CITY OF ALBUQUERQUE

February 24, 2012

Re: Lowes Subdivision Lot 3
Grading and Drainage Plan
Engineer's Stamp dated 2-8-12 (A14/D006B)

GRADING AND DRAINAGE PLAN

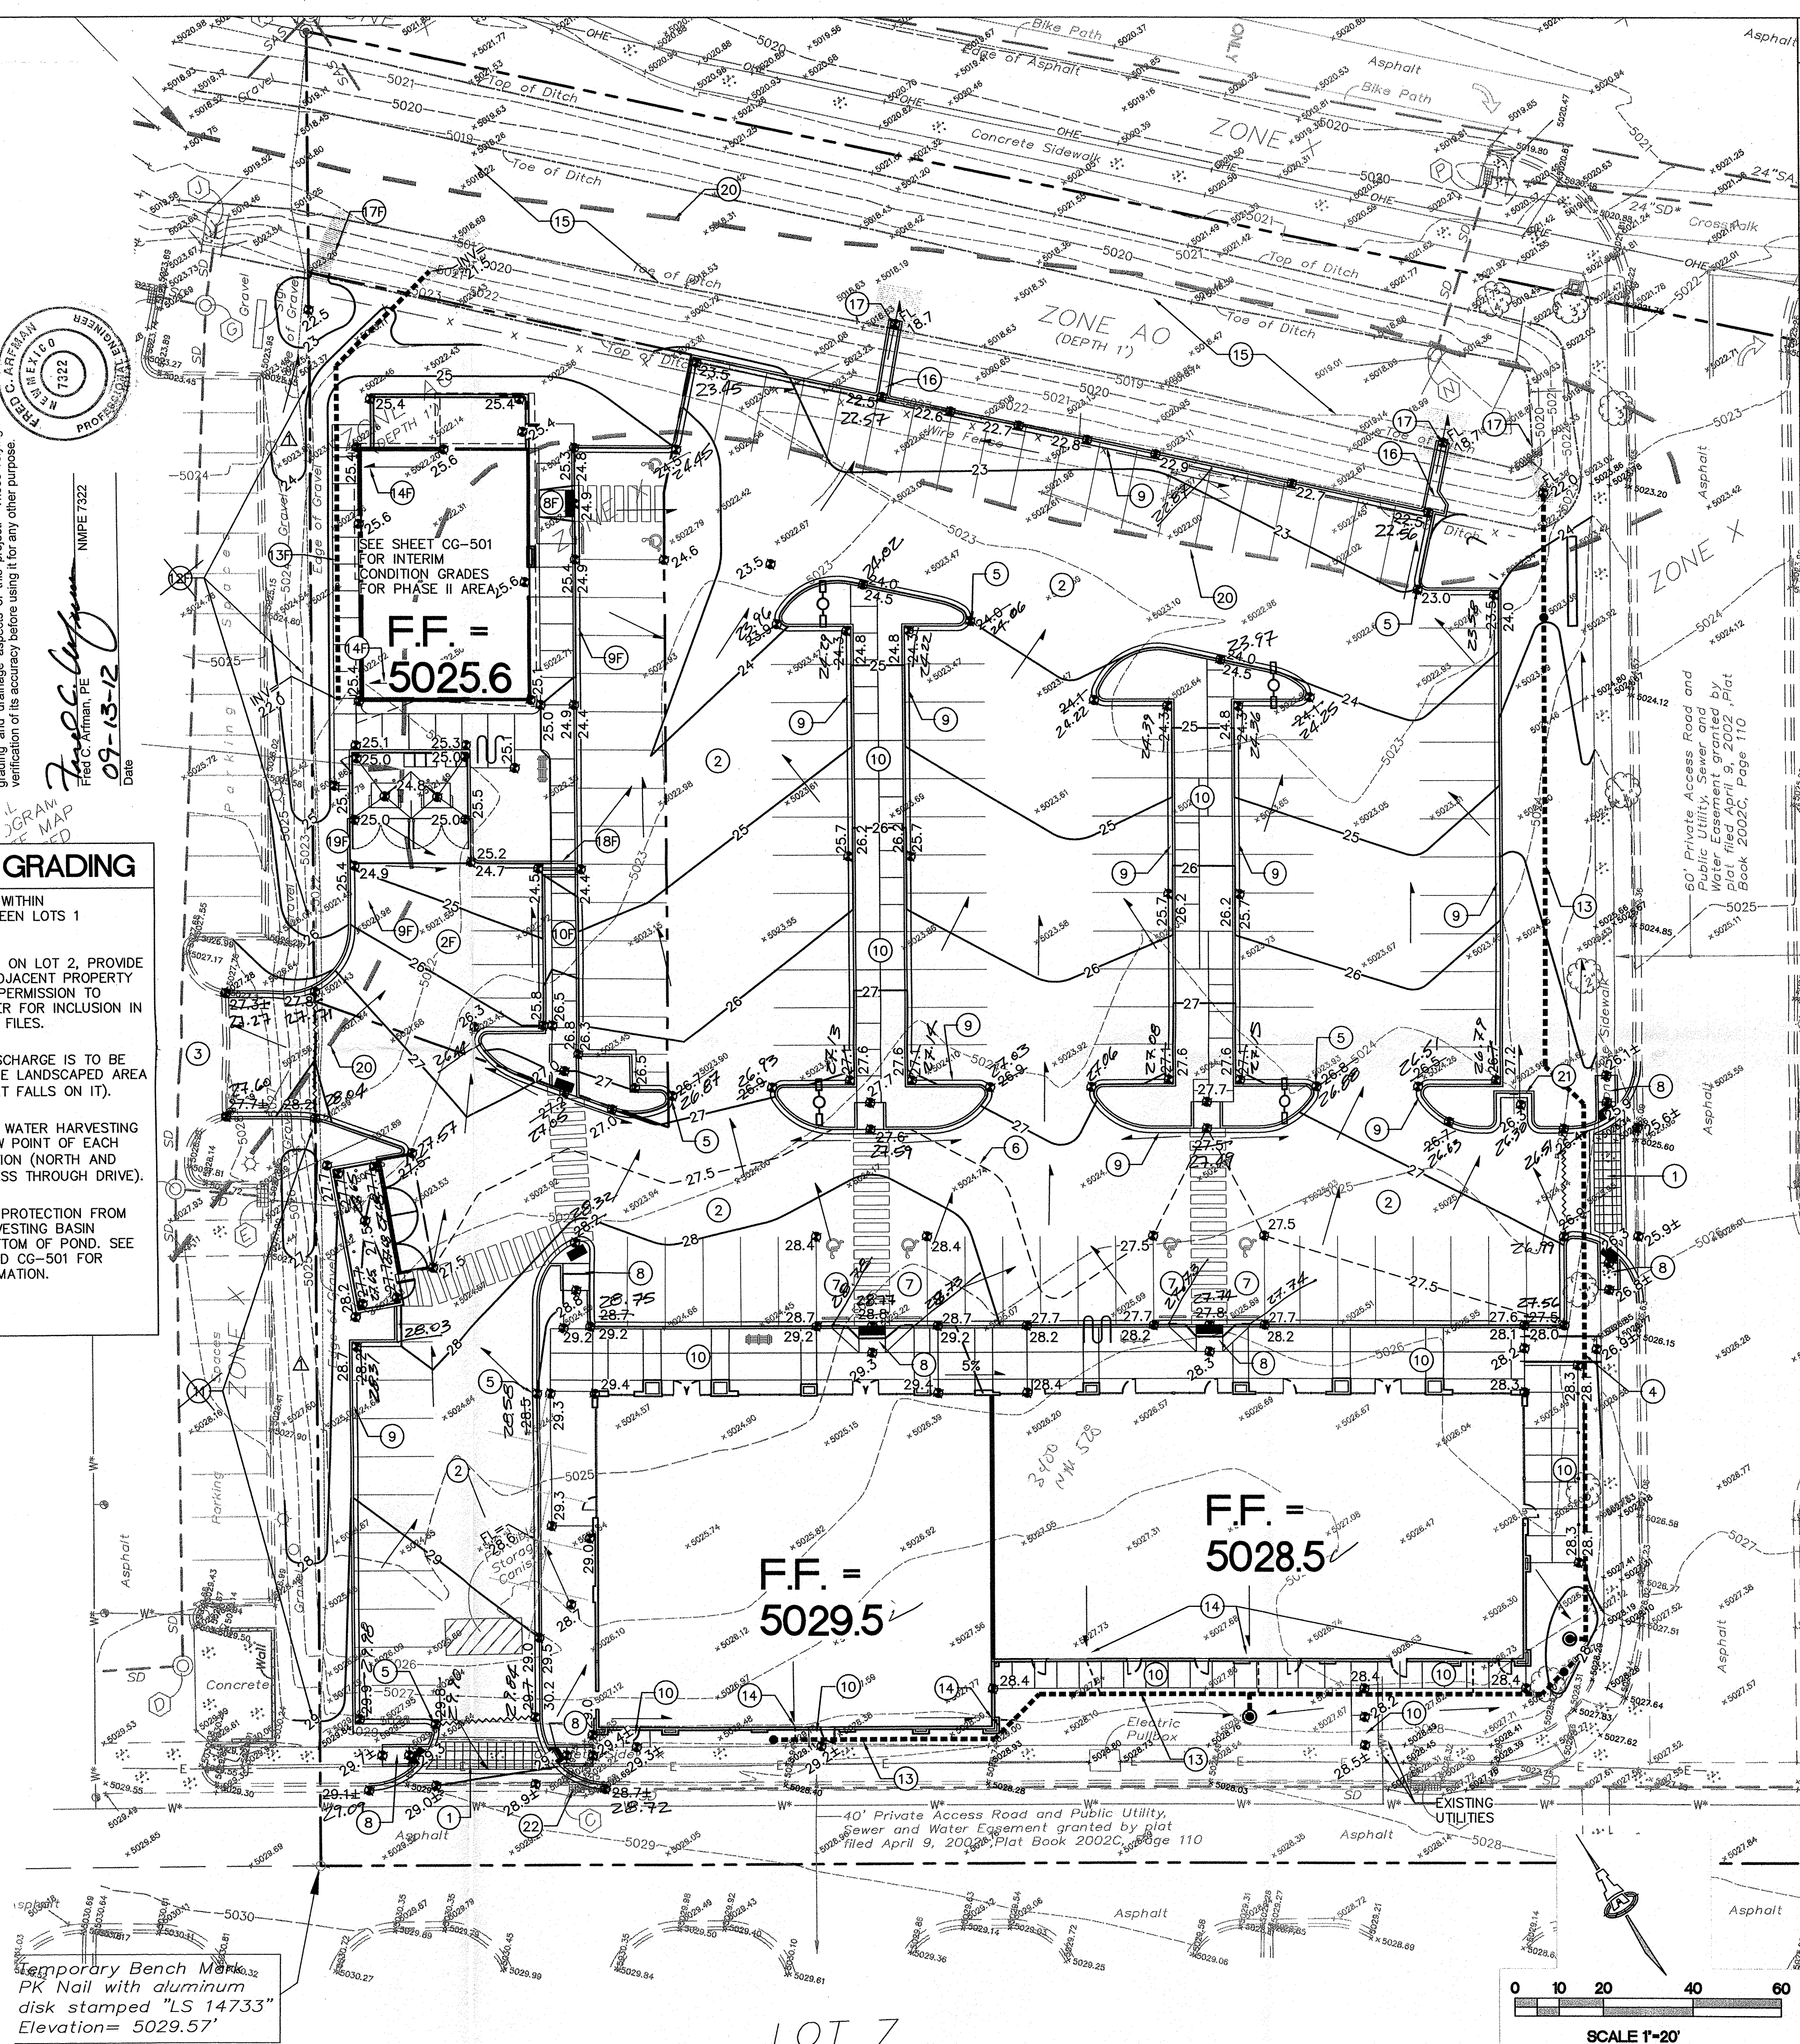
Before phase II can receive a C.O. an Elevation Certificate must be submitted for review and approval. Also, the dumpster pad must drain into the SAS via a grease trap.

Hydrology is requesting that all proposed landscape areas are depressed to retain/infiltrate the moisture that falls on them.

We have included two Floodplain Permit Forms - one for each of the two phases. Our client understands that an Elevation Certification will be required for the Phase II building until the LOMR being prepared by Chuck Easterling is accepted (see keyed note 20). General Note regarding depressed landscaping has been added to the plan.

2 STORM DRAIN EXHIBIT
Scale: 1"=30'

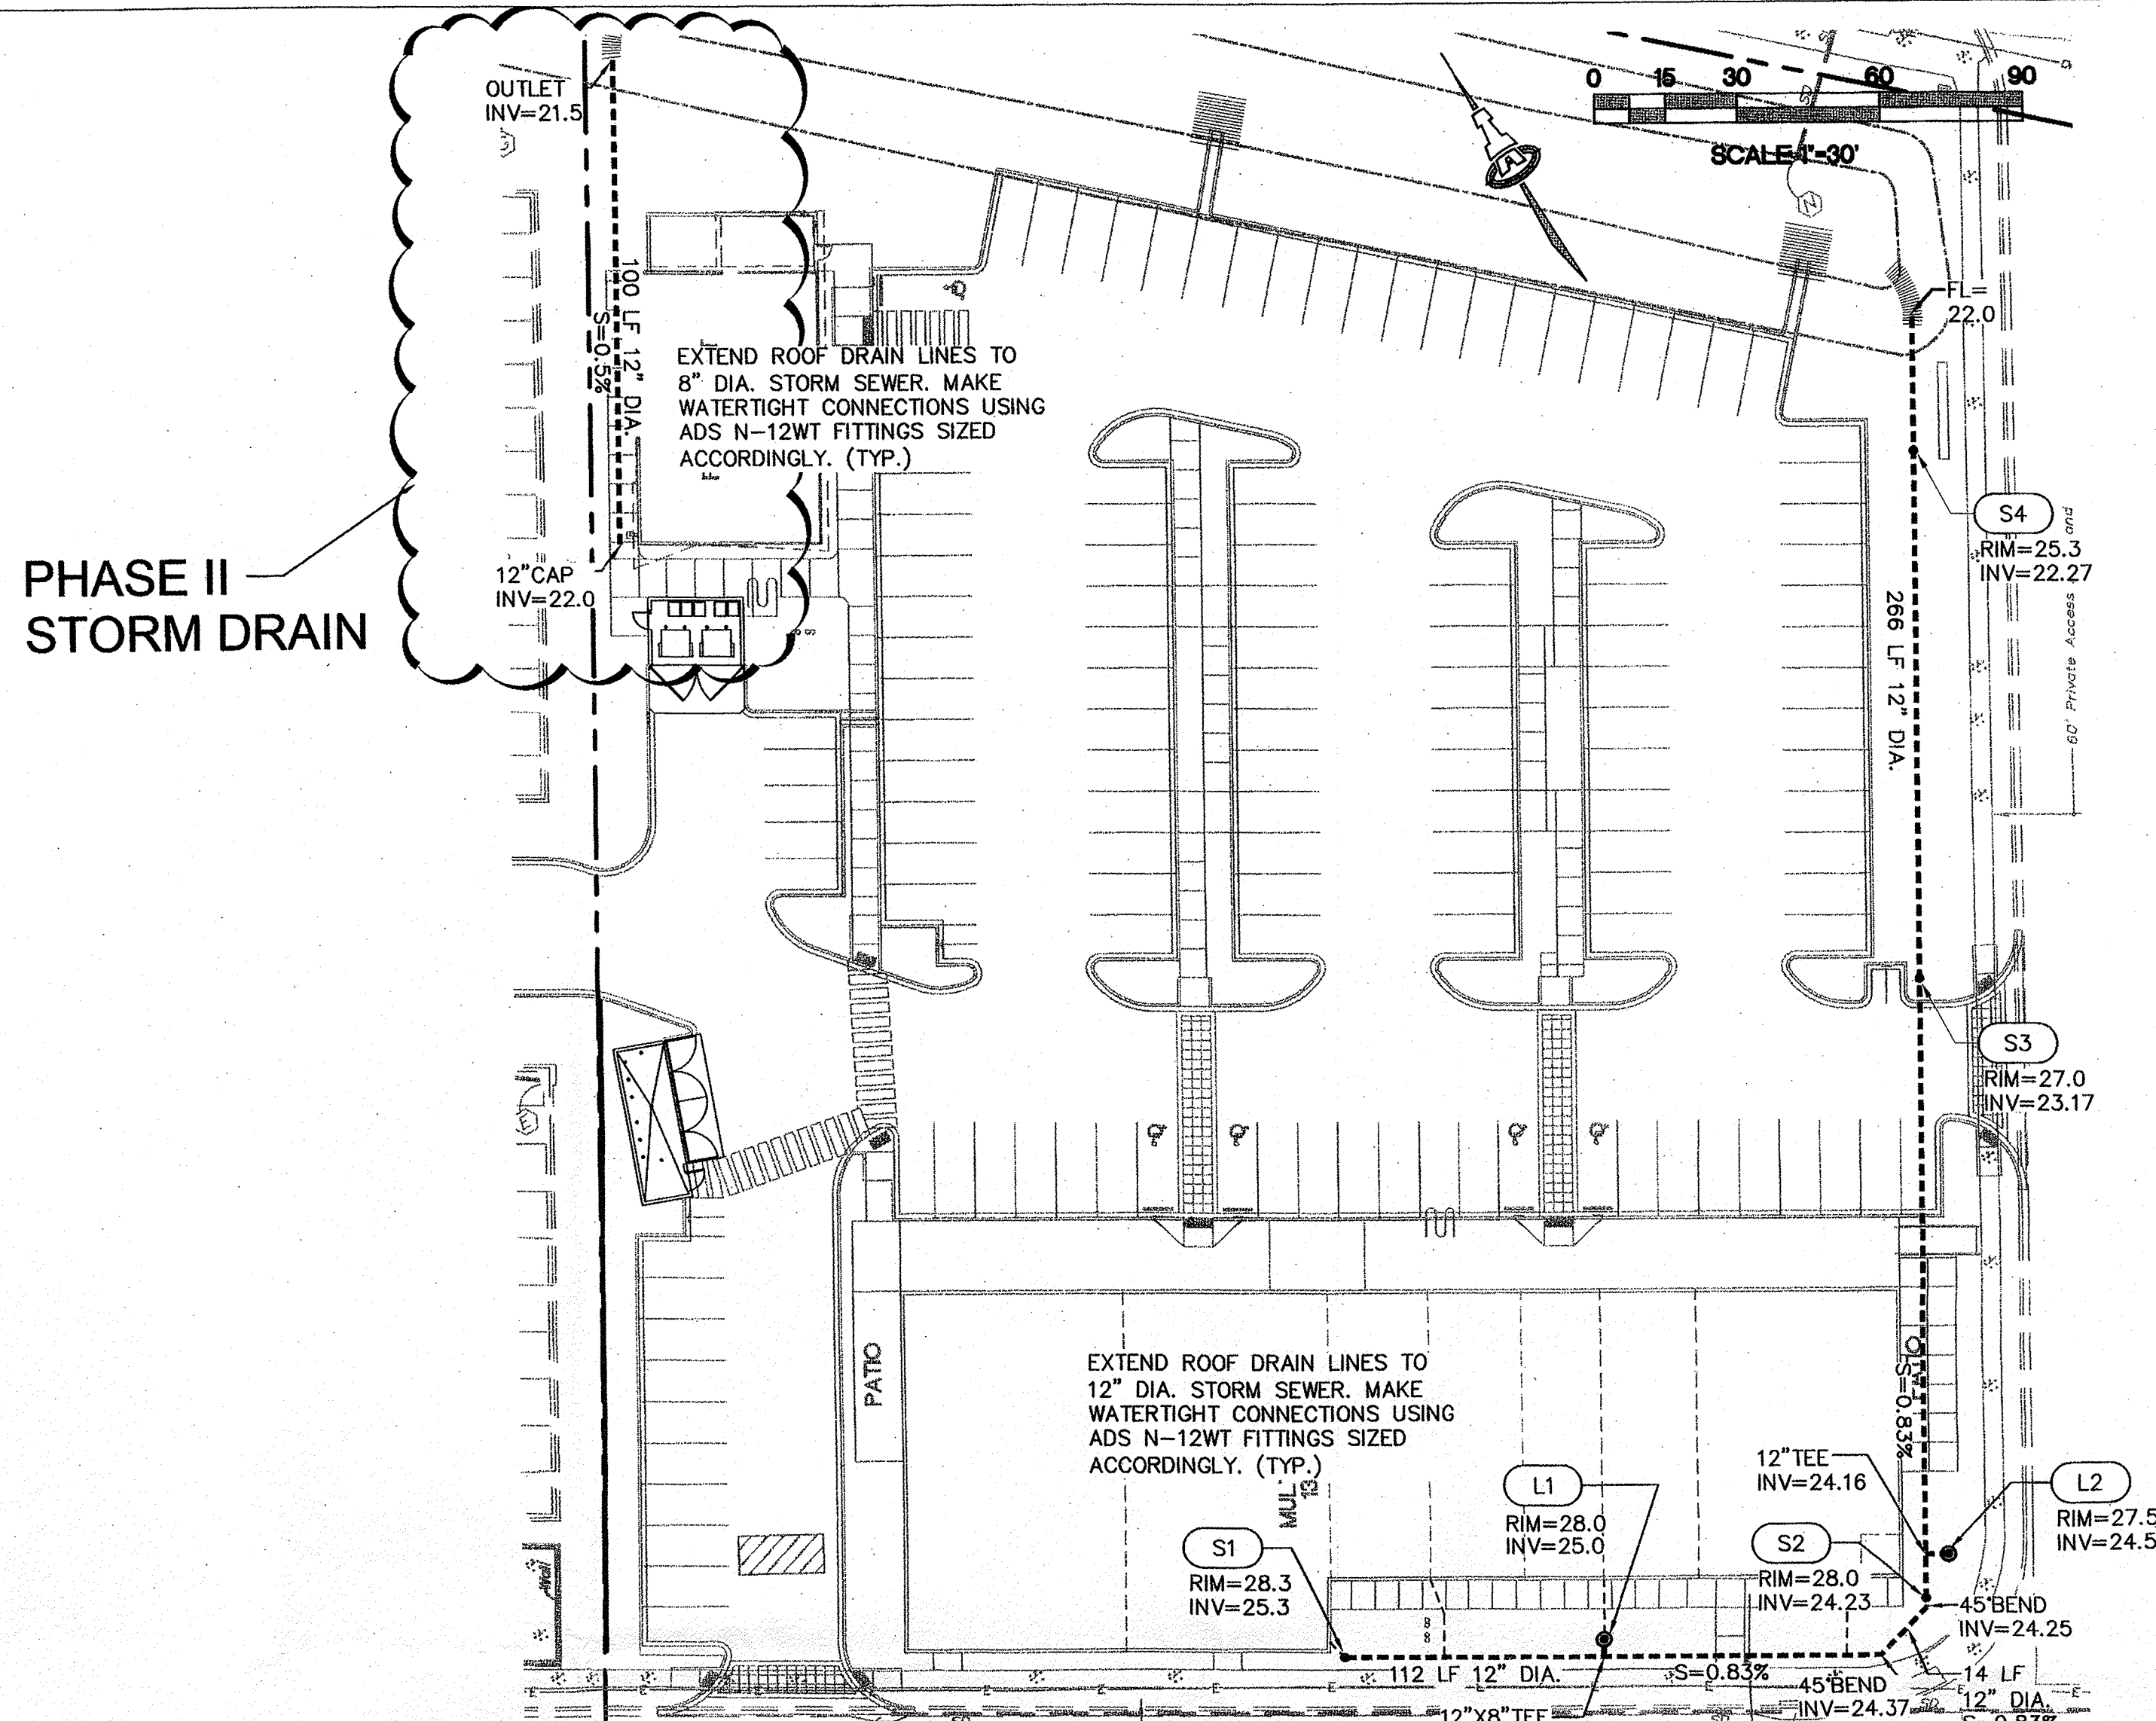
Per the attached exhibit and photographs, there is a double 'C' inlet just downstream of the single 'C' inlet which we are calling to modify to a Type 'D'. Any trash which may have been captured at the upstream 'C' will now be captured at the downstream 'C' (ALL INLETS ARE PRIVATE).
